KITTTITAS COUNTY DEPARTMENT OF PUBLIC WORKS

MEMORANDUM

TO: Dan Valoff, Community Development Services
FROM: Christina Wollman, Planner II *W*
DATE: January 31, 2007
SUBJECT: Iron Mountain Short Plat

Our department has reviewed the Plat application and has the following comments:

**CRUSE & ASSOCIATES**  
PROFESSIONAL LAND SURVEYORS  
217 E. Fourth St. P.O. Box 959  
Ellensburg, WA 98926 (509) 962-8242  
**IRON MOUNTAIN SHORT PLAT**

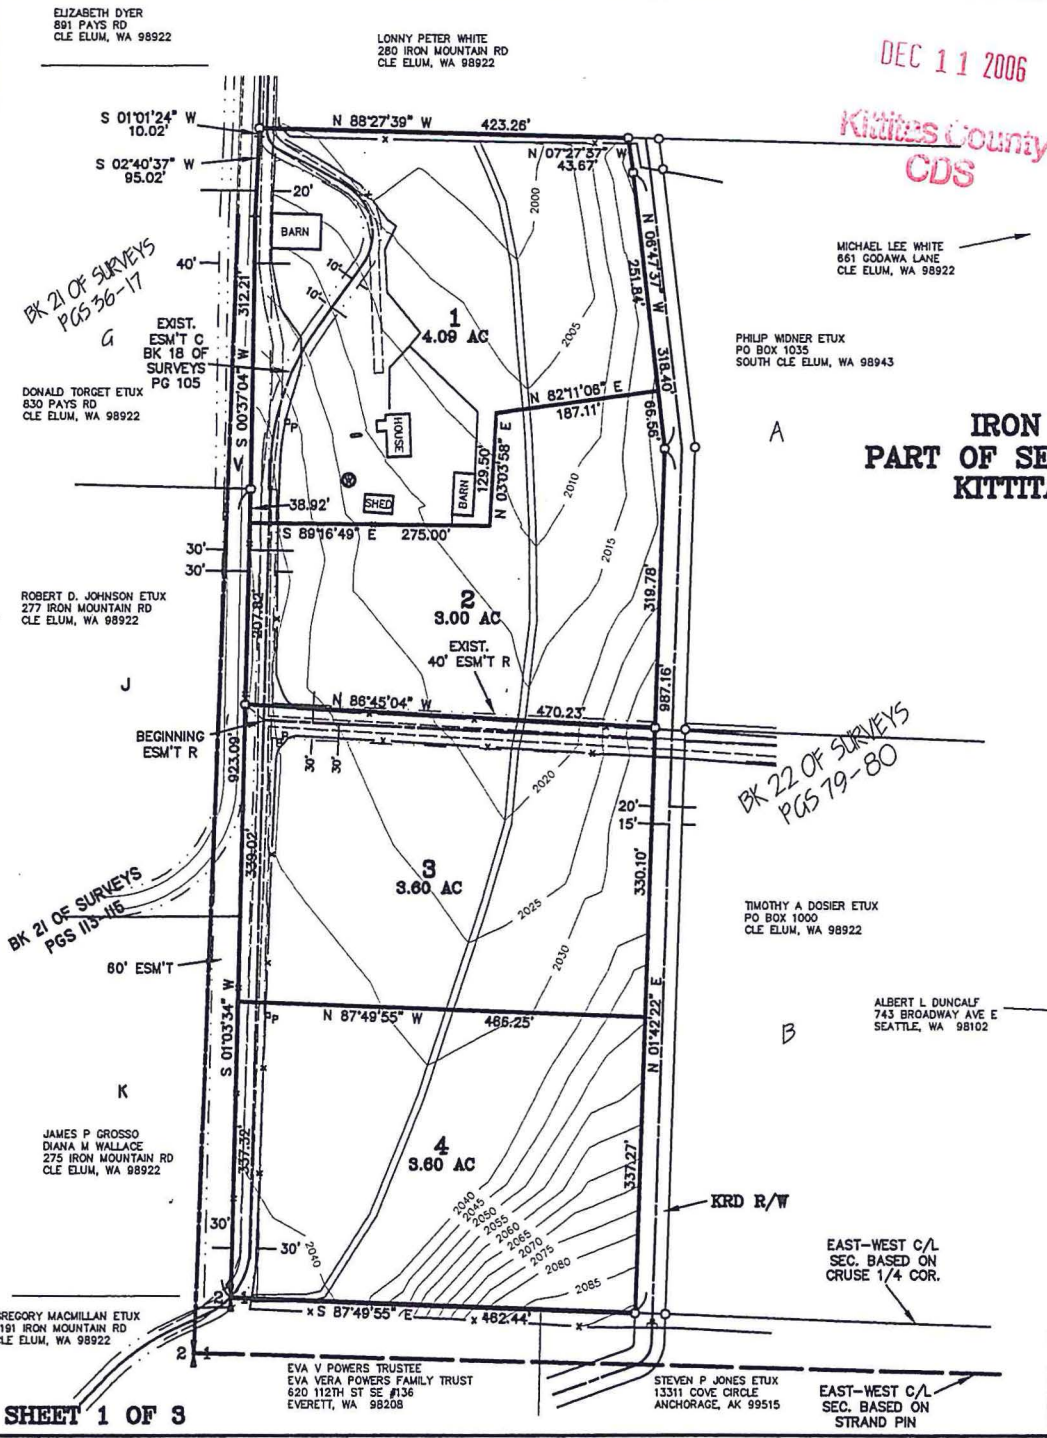
1. Private Road: The applicant has applied for and received approval for a variance request from the required 60' easement requirement as identified in the current Kittitas County Road Standards for low-density private roads. The following are conditions of the variance request and shall be applied as conditions of this short plat:

It shall be the applicant's responsibility to secure a continuous and common 60' wide ingress and egress easement for the remainder of Iron Mountain Road that serves the subject property. The 60' wide easement shall be required from the point at which the existing 30' easement, cross the section line, east, into section 2, then from that point, south, to a point at which it serves parcels 19-15-01000-0004 (7.09 Acres) and 19-15-01000-0033 (20.00 Acres) as required for access to the proposed development. The applicant shall improve the existing road to a minimum of 20' traveled way width with 1' gravel shoulders, as required by Fire Code and current Kittitas County Road Standards. This can be accomplished by either widening the existing road with gravel, compacted to 95% and able to support a minimum load of 75,000 lbs as needed for Fire Apparatus or to widen the existing paved driveway to a 20' paved traveled way width with 1' gravel shoulders, compacted to 95% and able to support a minimum load of 75,000 lbs as

needed for Fire Apparatus per Fire Code and current Kittitas County Road Standards. This is the minimum requirement for a Low Density road providing access for 3 to 40(+) parcels that average over 5.01 acres in size.

3. Cul-de-Sac: Permanent deadend streets shall have a turn-around having an outside right-of-way easement diameter of at least 110' (55' radius) at the closed end. See Kittitas County Road Standards, 9/6/05 edition.

- a. Reference AASHTO for cul-de-sac design.
 - b. Contact the Fire Marshall regarding any additional cul-de-sac requirements.
4. Plat Notes: Plat notes shall reflect the following:

- a. Plat note #9 shall be removed.
 - b. "Entire private road shall be inspected and certified by a civil engineer licensed in the State of Washington specifying that the road meets Kittitas County Road Standards as adopted September 6, 2005, prior to the issuance of a building permit. Any future subdivision or land use action will be reviewed under the most current road standards."
